Department of Primary Industries

OUT15/24050

Ginkgo Mineral Sands Mine Waste Management Modification (DA 251-09-01)

Comment by DPI Water

Figure 3: On-site Landfill

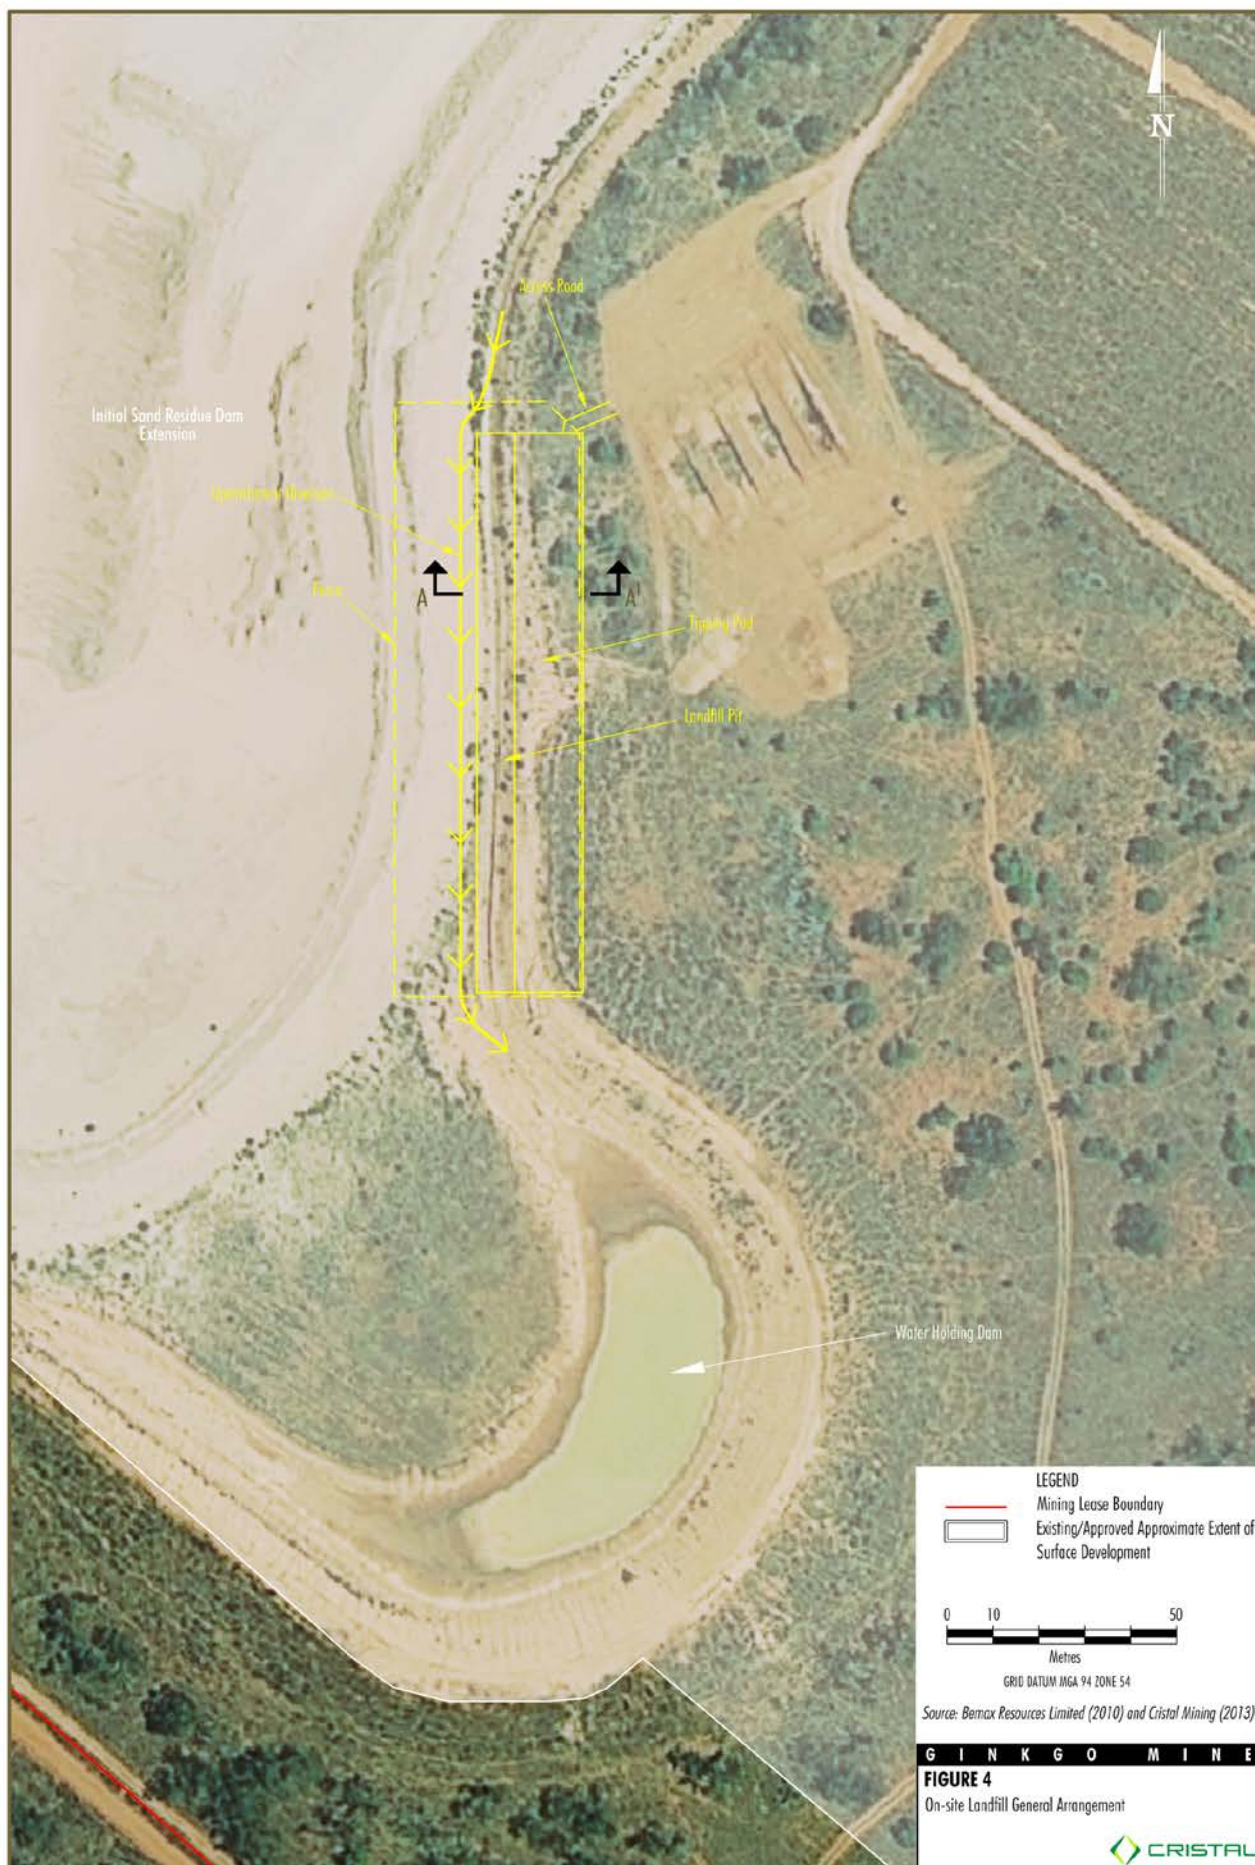
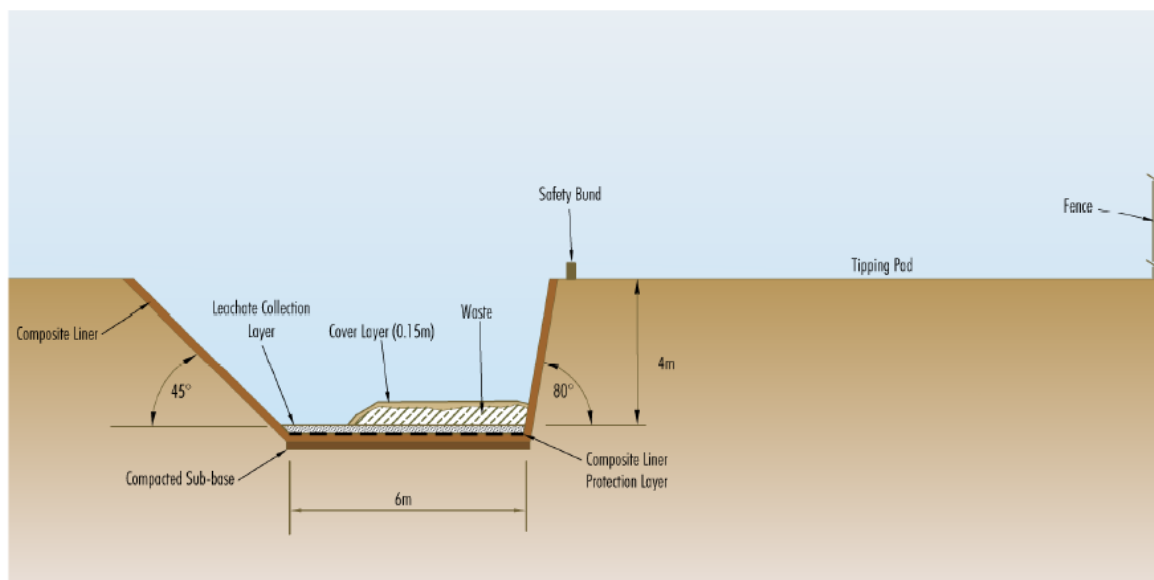
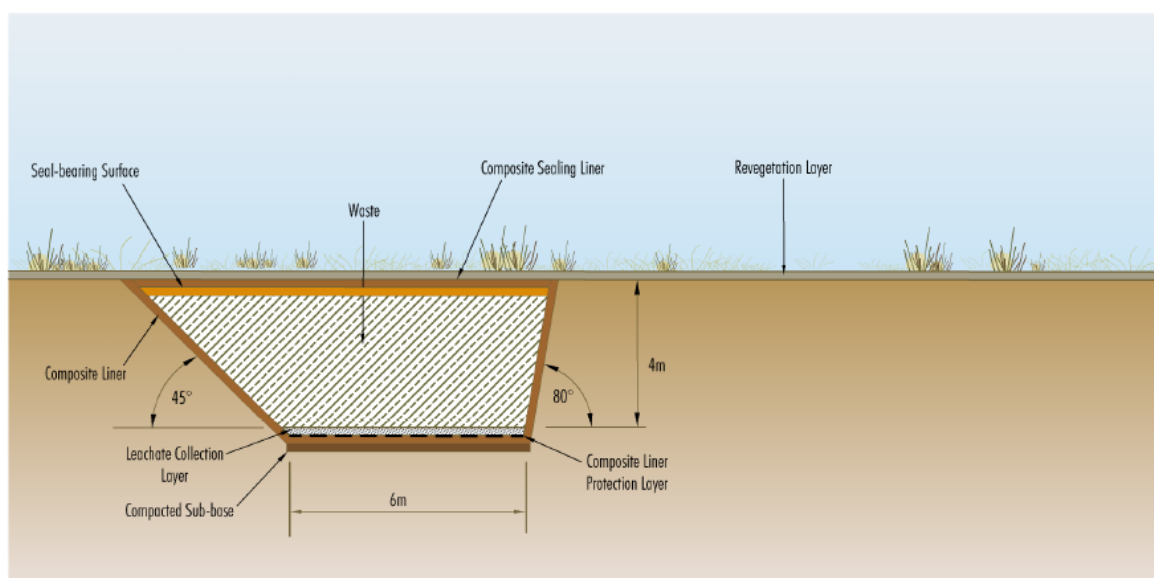
- The proposed design of the on-site landfill, leachate holding dam and the continued implementation of the Borefield Impact Management Plan ensure that the risk to the groundwater resource is low. DPI Water recommends the following:

- monitoring of the volume of pumped leachate to identify changes that may indicate leakage from the barrier system and the need for contingency responses.

- monitoring of the holding dam water level to ensure adequate freeboard for the design rainfall event and removal as required.

Figure 4: Proposed Landfill Cross Section (Operational and Rehabilitated)

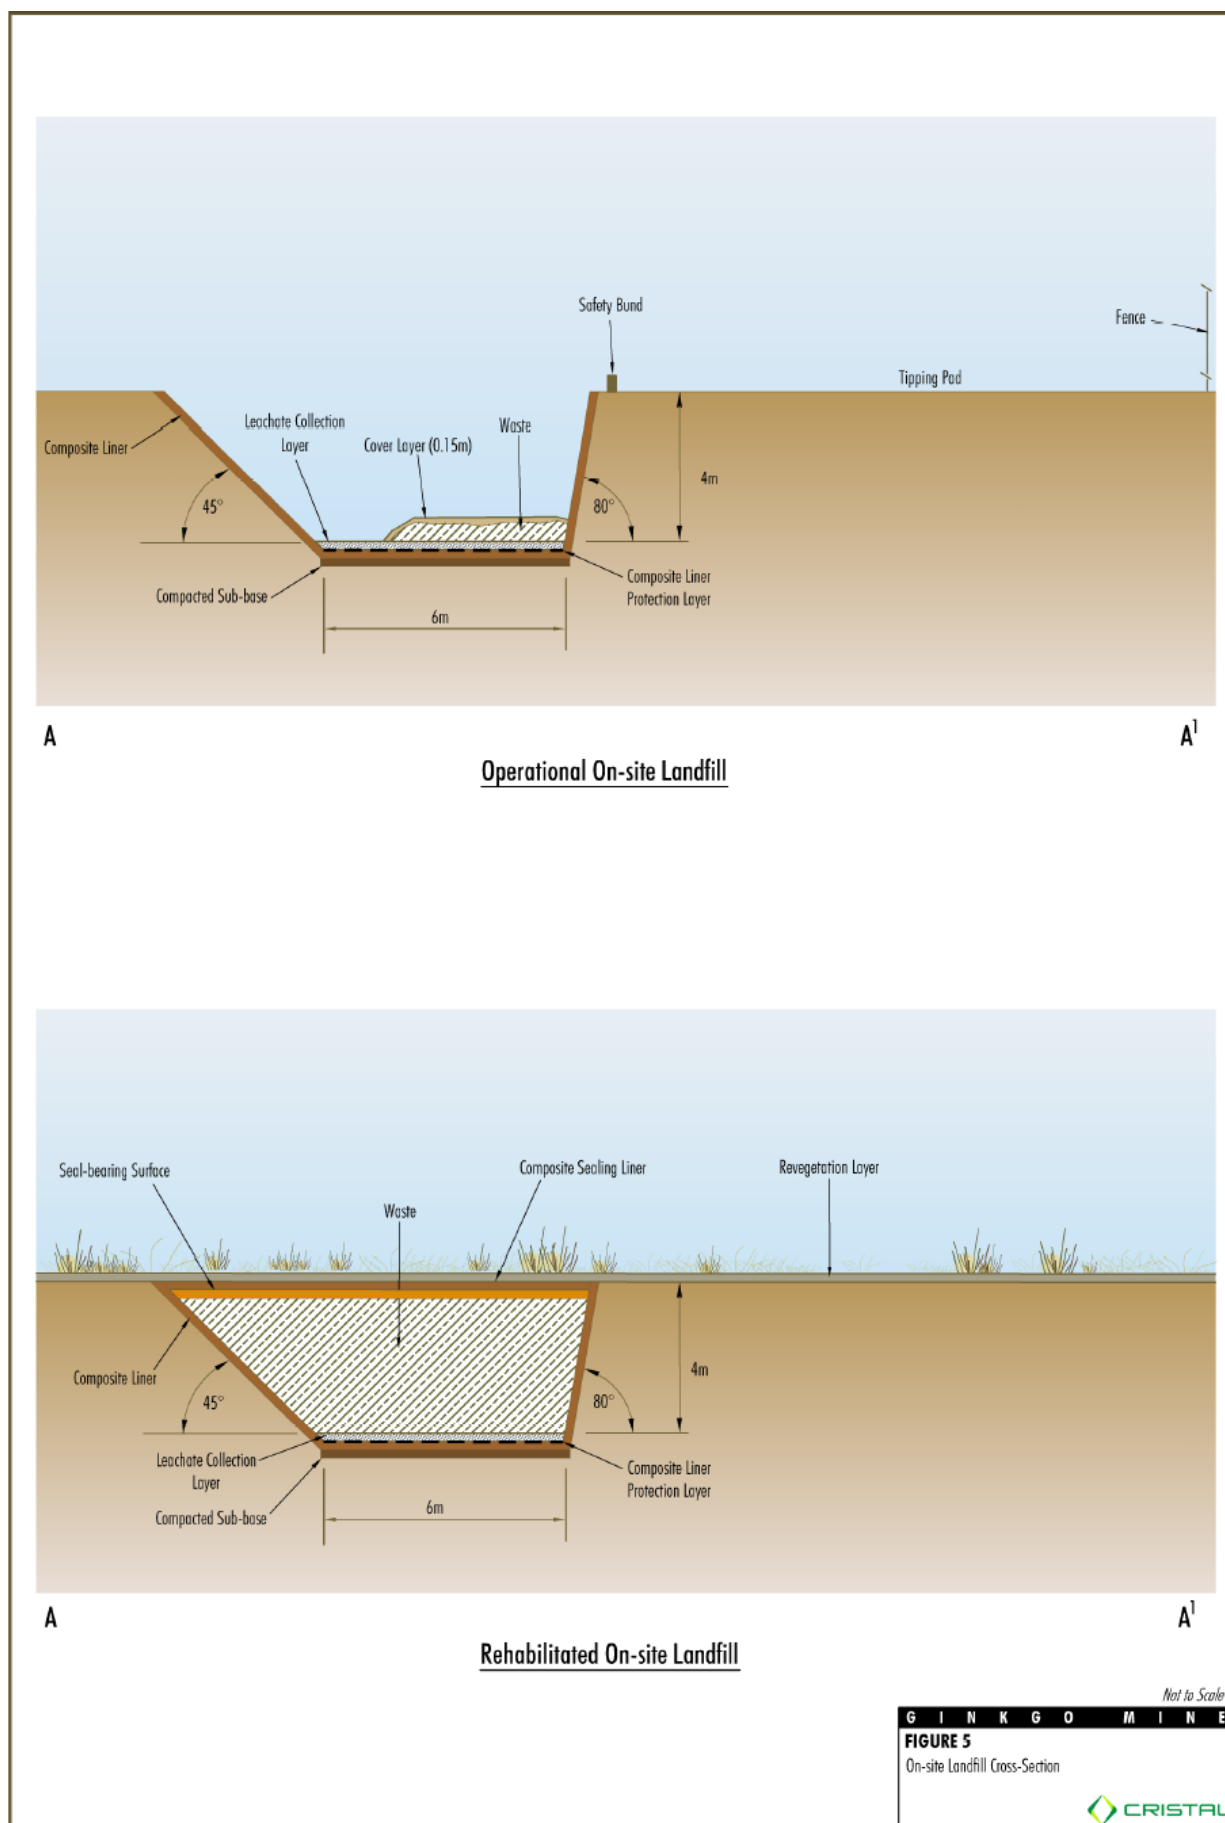
- The on-site landfill is proposed to be designed and operated in consideration of the Draft Environmental Guidelines: Solid waste landfills (EPA 2015) which is considered appropriate. The base of the proposed facility will consist of a liner with a 0.2 m thick compacted sub-base to provide a stable base for the composite liner. Two alternatives are being considered for the composite liner, these are:

- clay liner with a flexible membrane liner; and
 - geosynthetic clay liner with a flexible membrane liner.

Both of these options provide a low permeability barrier for the prevention of leakage migration and a level equivalent or greater than the EPA (2015) requirement of 1×10^{-9} m/s. This will be overlain by a composite liner protection layer to protect it from the leach collection layer.

- The leachate collection layer will consist of approximately 0.3m of gravel placed over the composite liner protection layer to promote drainage of the leachate. The leachate collection layer is to include polyethylene collection pipes draining to a collection sump to enable pumping out of leachate to a holding dam for disposal via evaporation. The holding dam is also proposed to include a leachate barrier system which is supported.
